Response to Planning application from Hertfordshire County Council (T and CP GDP Order 2015)

District ref: 6/2024/1528/COND
HCC ref: WH/22088/2024
HCC received: 23 August 2024
Area manager: Manjinder Sehmi
Case officer: Paul Marshall

YMCA 90 Peartree Lane Welwyn Garden City AL7 3UL

Submission of details pursuant of Conditions 7 and 35 (External Lighting) and Conditions 18 and 46 (Electric Vehicle Charging) on planning permission 6/2019/2714/OUTLINE

Client	KORI		
Project	YMCA PEARTREE LANE WELWYN GARDEN CITY		
Title	EXTERNAL LIGHTING LAYOUT		
Drawing Type	CONSTRUCTION		
Drawing No.	11600-E-600	Revision	C01
Scale	1:100	Original Size	A0
Date	01.12.22		
Drawn	NC	Engineer	NC
Checked	TH

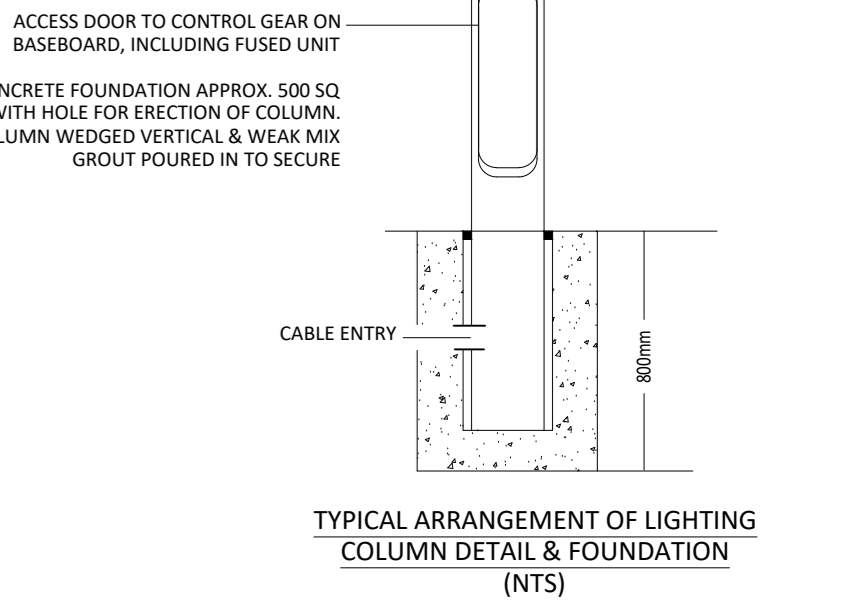
Drawing 11600-E600 Rev CO1 illustrates electric vehicle charging points therefore Conditions 18 and 46 have been met and therefore are discharged.
